Bramford to Twinstead Reinforcement

**Document 8.5.3.3: Applicant's Comments on Babergh District Council
Additional Local Impact Report**

**Final Issue A
October 2023**

Planning Inspectorate Reference: EN020002

TITLE  
 2.11.7 DESIGN AND LAYOUT PLANS: STOUR VALLEY EAST CABLE SEALING END COMPOUND

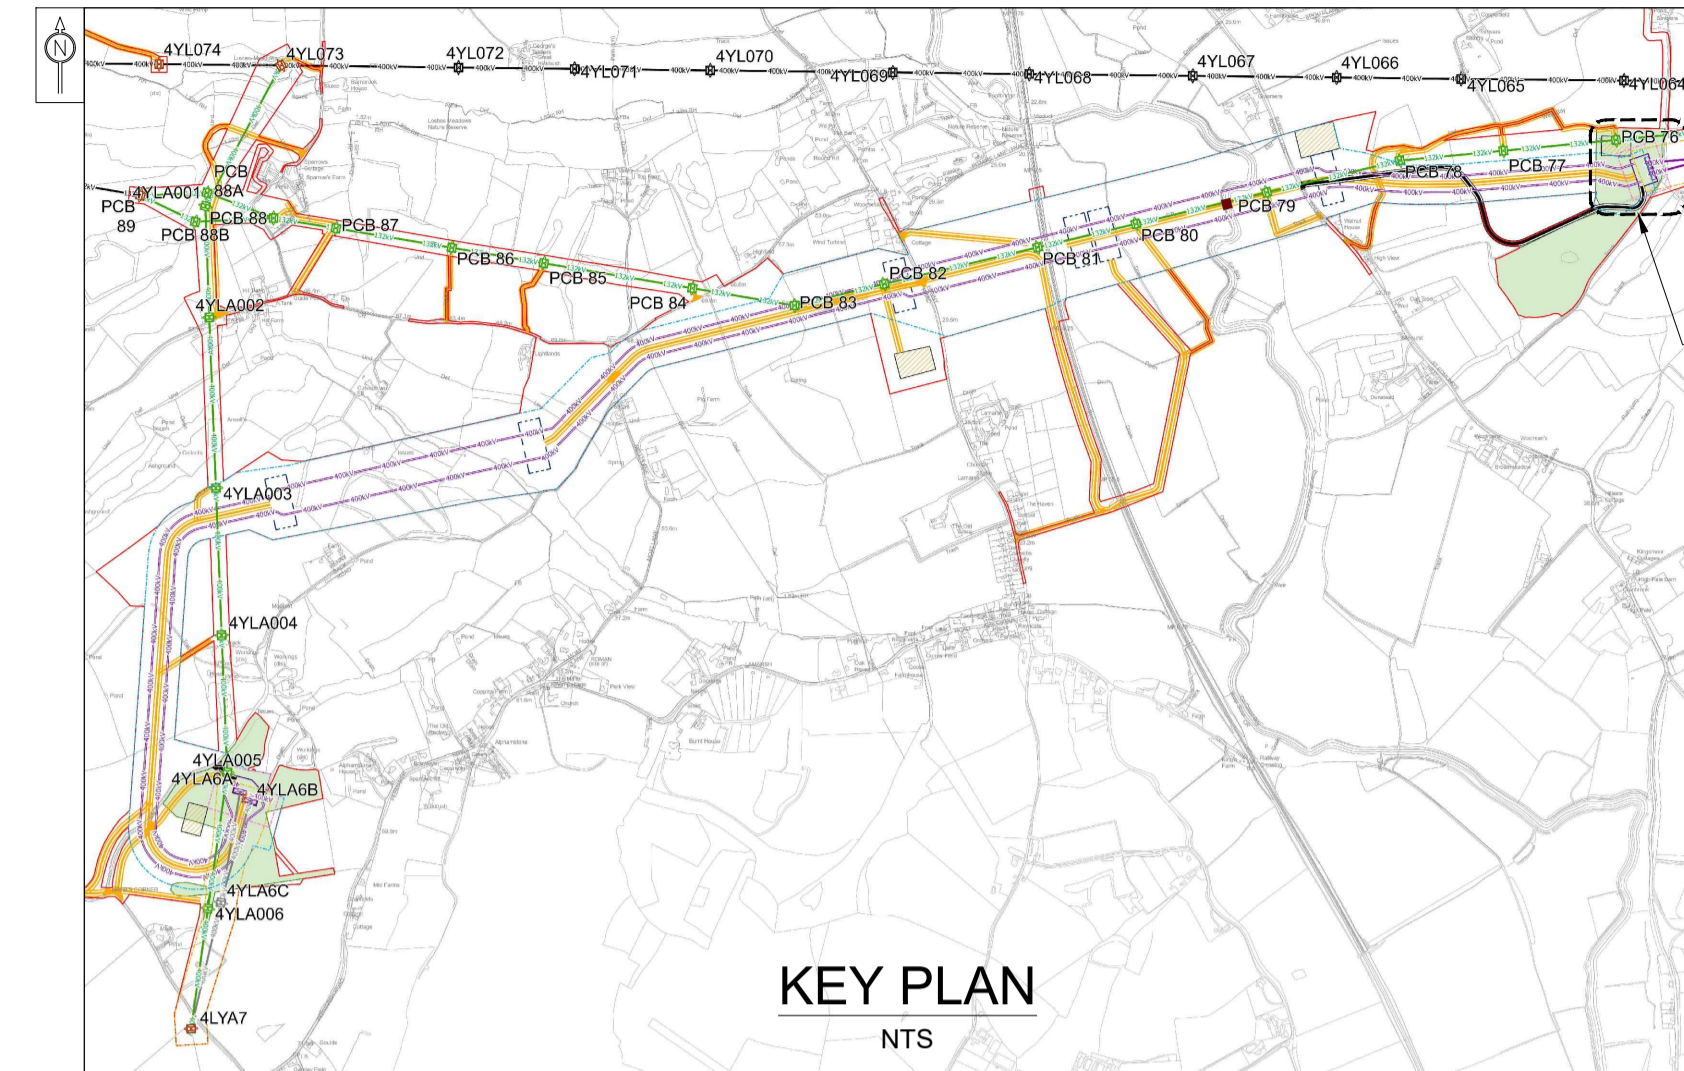
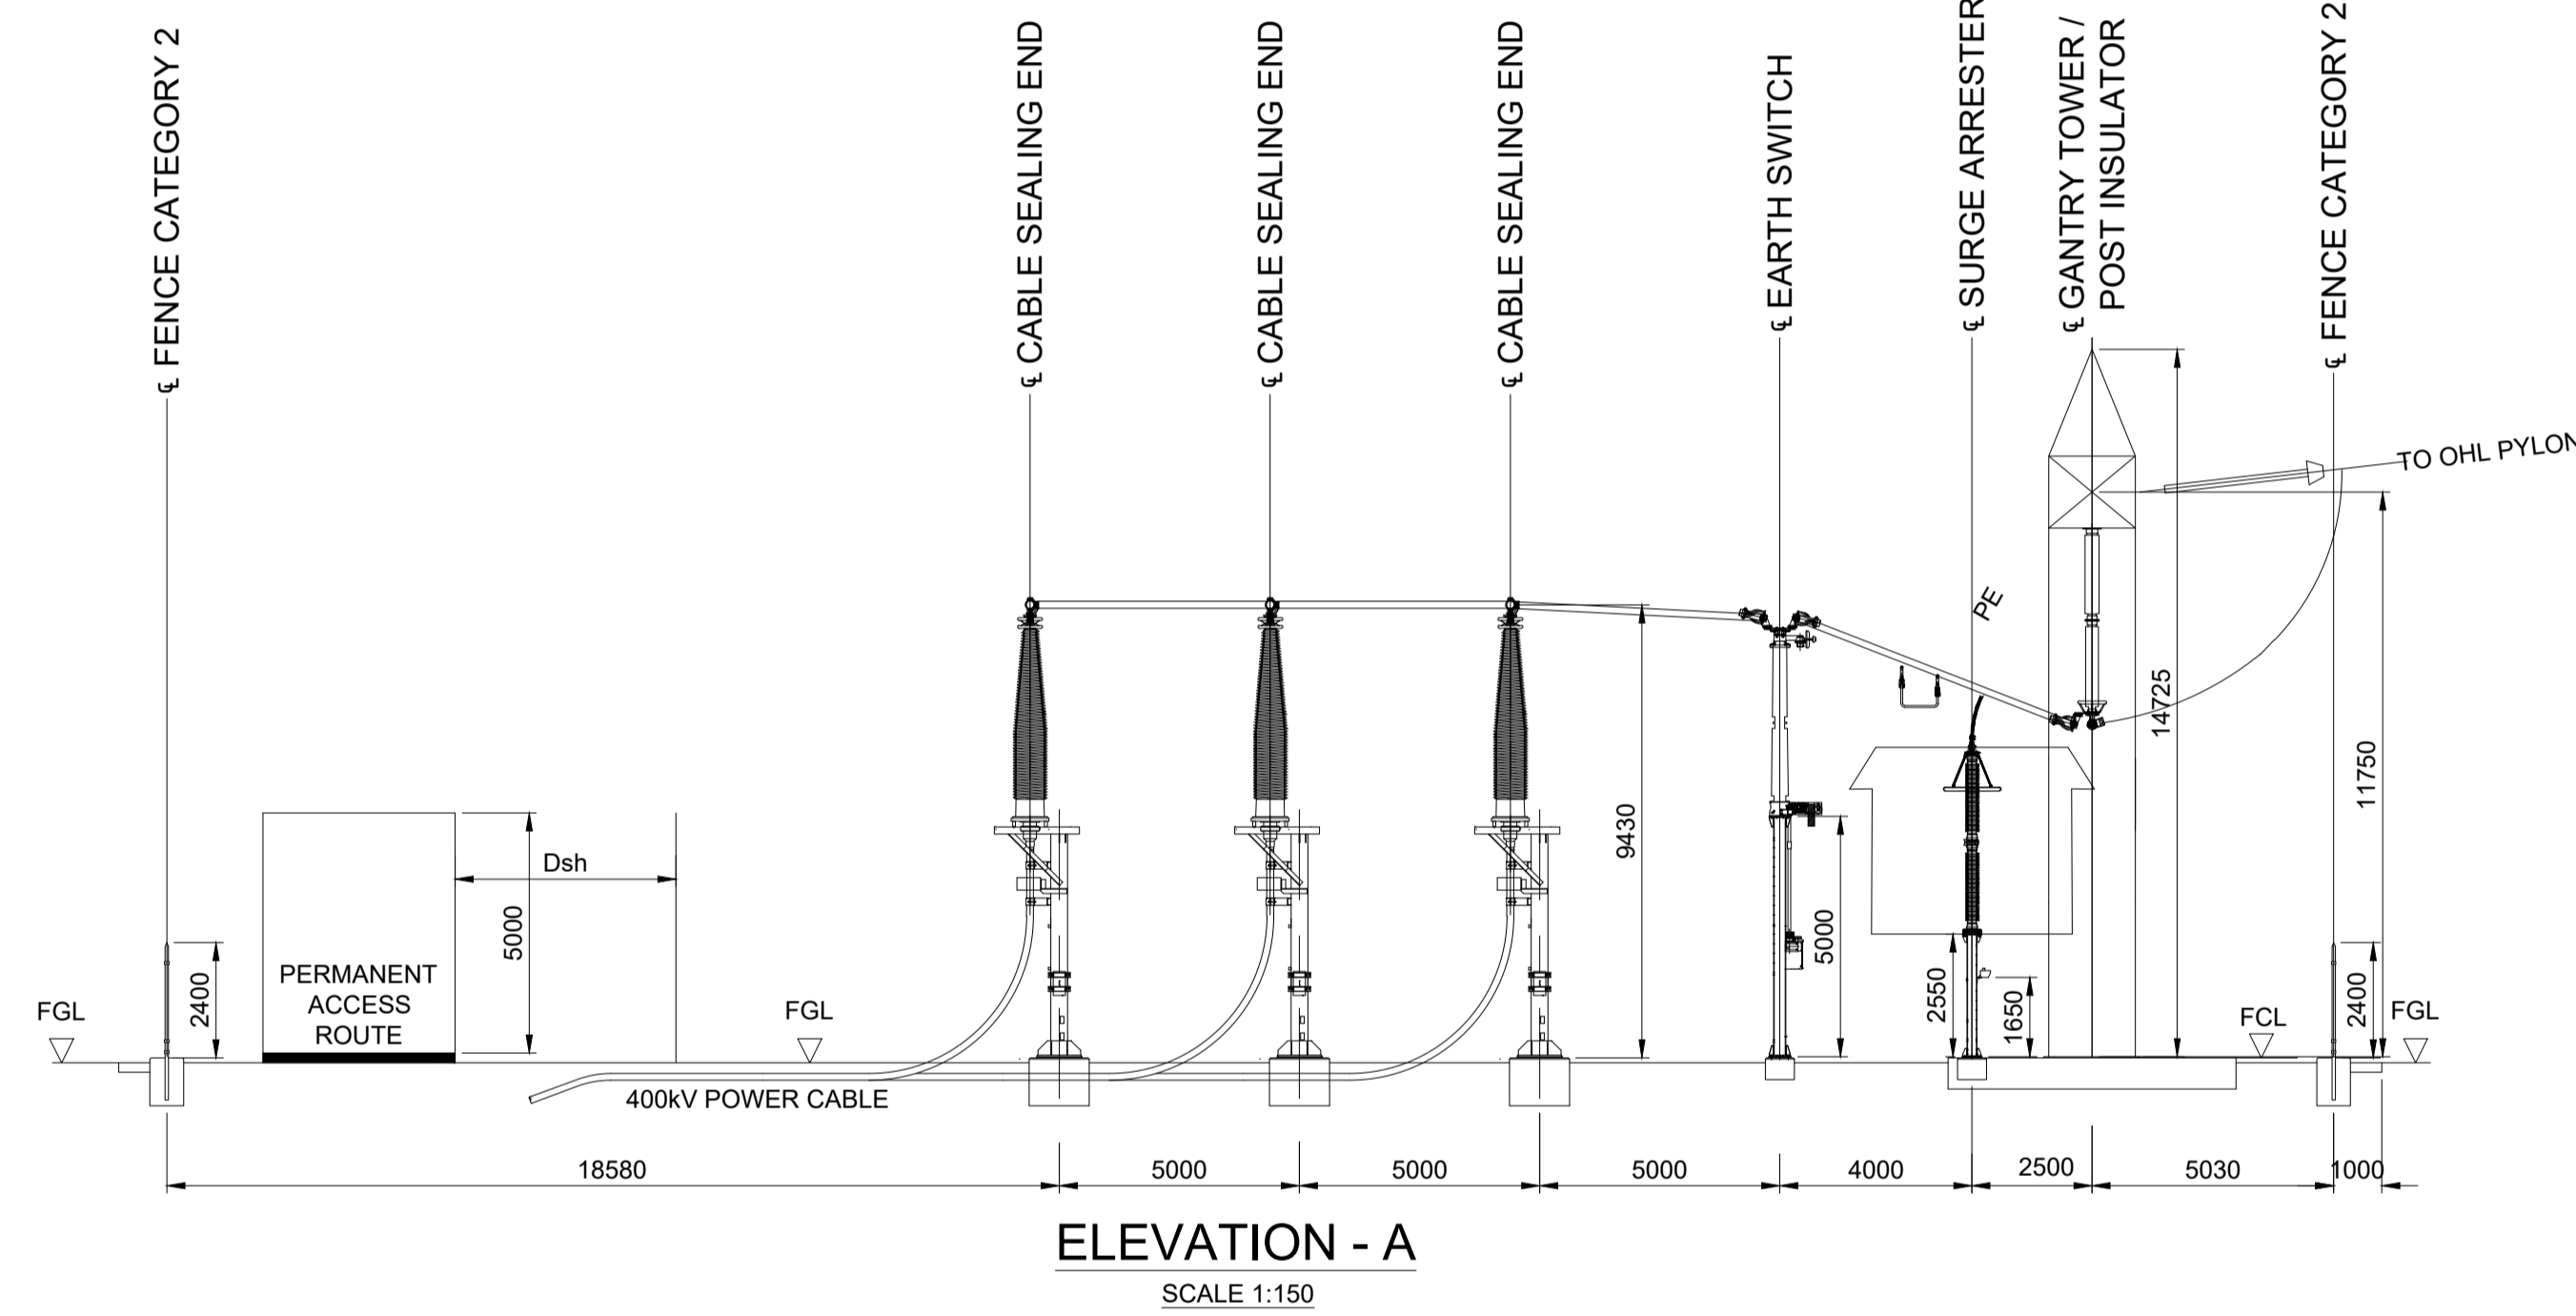
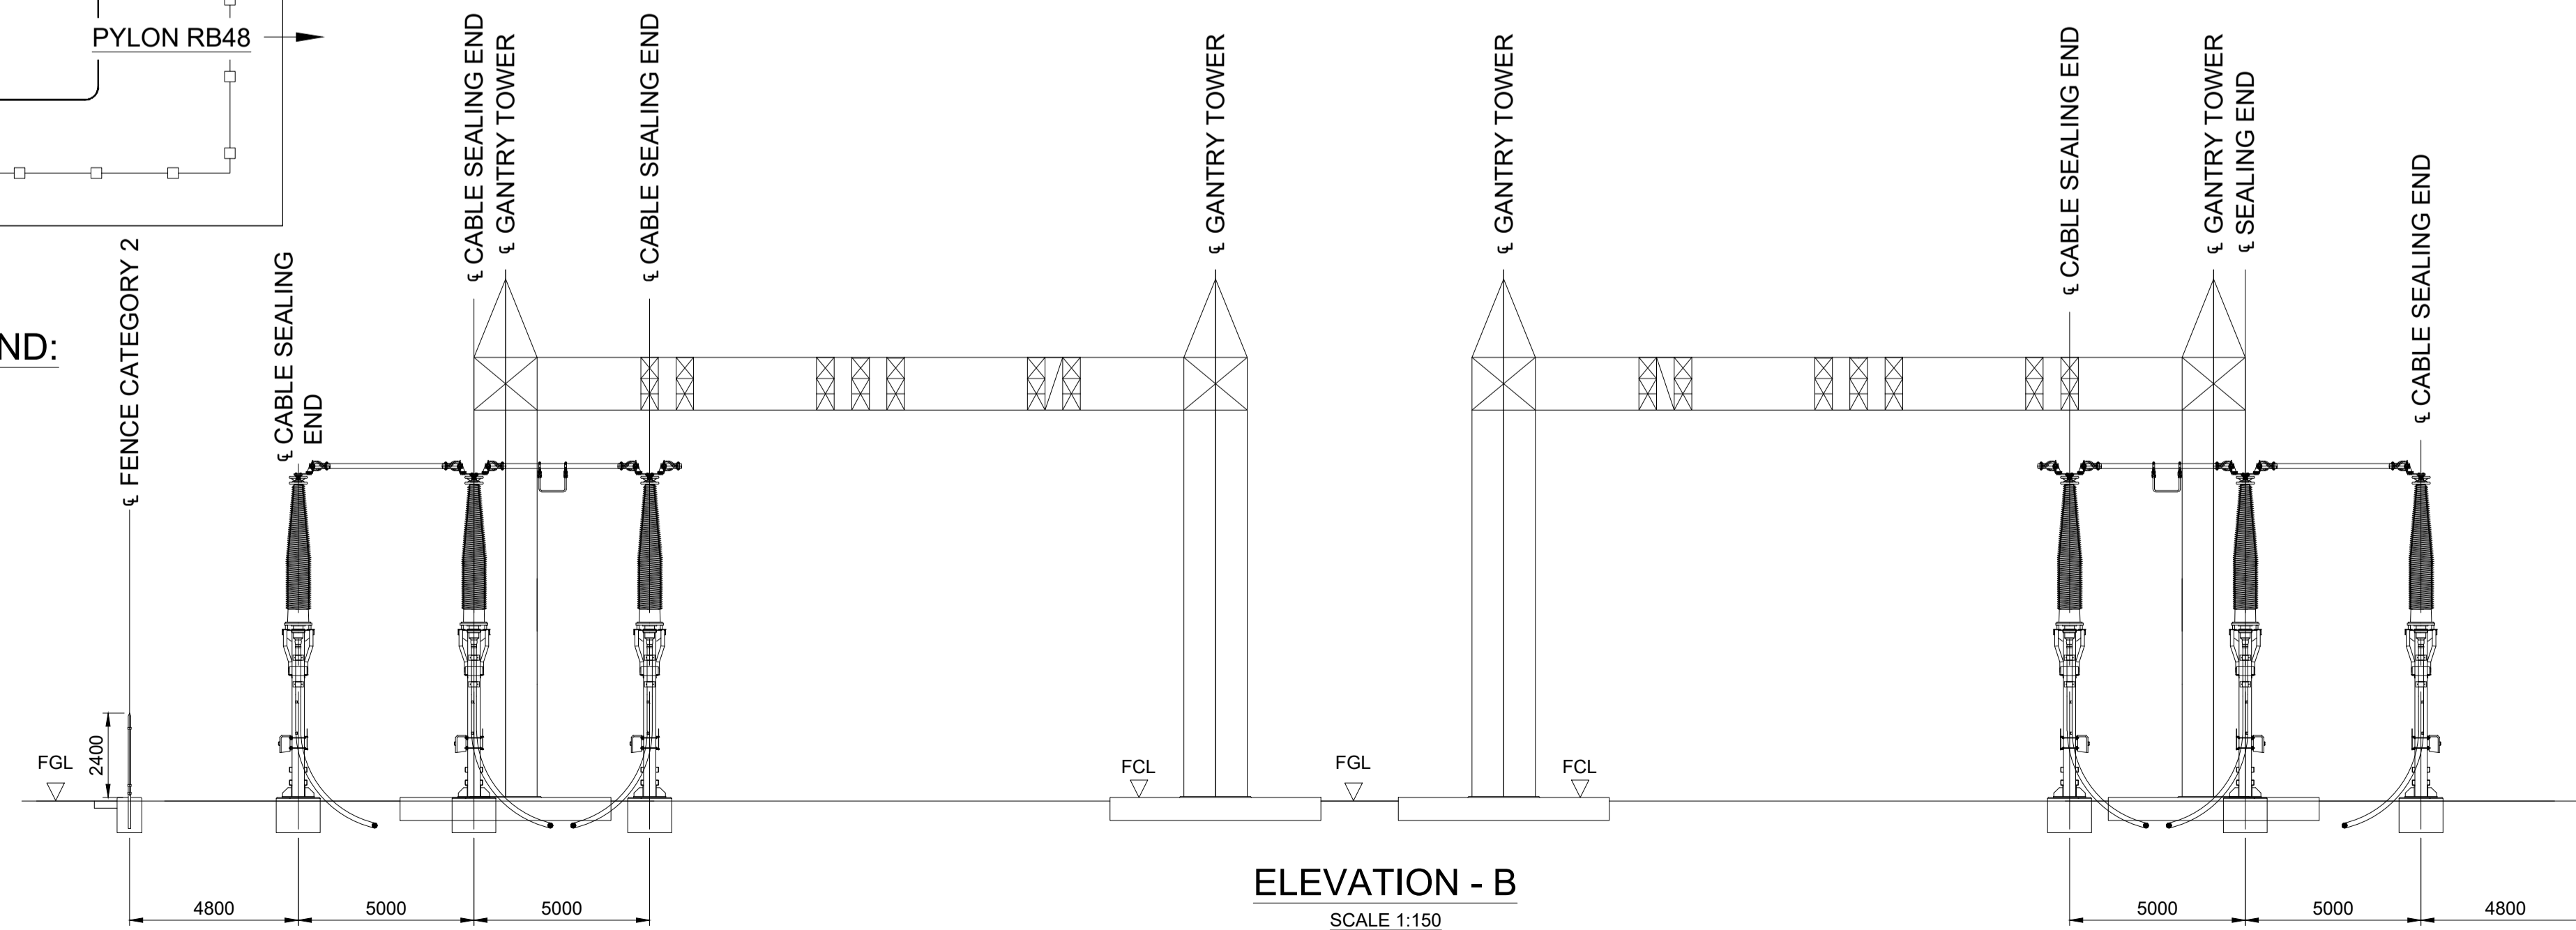
Reference	Point Raised	Applicant's Comments
2.2	The Typical Design and Layout Plans for the Stour Valley CSE Compound (Figure 3.3.4 Typical Design and Layout Plans: Stour Valley East CSE Compound January 2022) do not show the proposals in their context, nor indicate possible mitigations, making landscape and visual effects hard to judge. The compound structures are approximately 37.4m x 74.1m x 14.3m to the top of the gantries.	<p>The viewpoint assessment for the Stour Valley is presented at ES Appendix 6.4: Viewpoint Assessment Section G Part 6 [APP-106]. The photomontages for relevant viewpoints are presented at Photomontages Appendix 3 Part 3 [APP-065].</p> <p>The photographs provided for viewpoints G-02, G-03, G-04, G2.5 and G-24 [APP-106] and the photomontages for viewpoints G2.5 and G-24 [APP-065], illustrate how from most locations, the topography and existing vegetation would screen and filter views of the CSE compound including the gantries, which are the tallest part of the compound infrastructure. Viewpoint G2.5, although at some distance, was one of the few locations identified which would have visibility of the gantries. The photomontage prepared for this viewpoint [APP-065] shows that by Year 15 the gantries would be barely discernible in this wide view from the Stour Valley. This is due to the existing vegetation and embedded planting, which by Year 15 would be maturing.</p> <p>The proposed planting at the CSE compound is shown on Sheet 19 of LEMP Appendix B: Vegetation Reinstatement Plan (document 7.8.2(B)).</p>
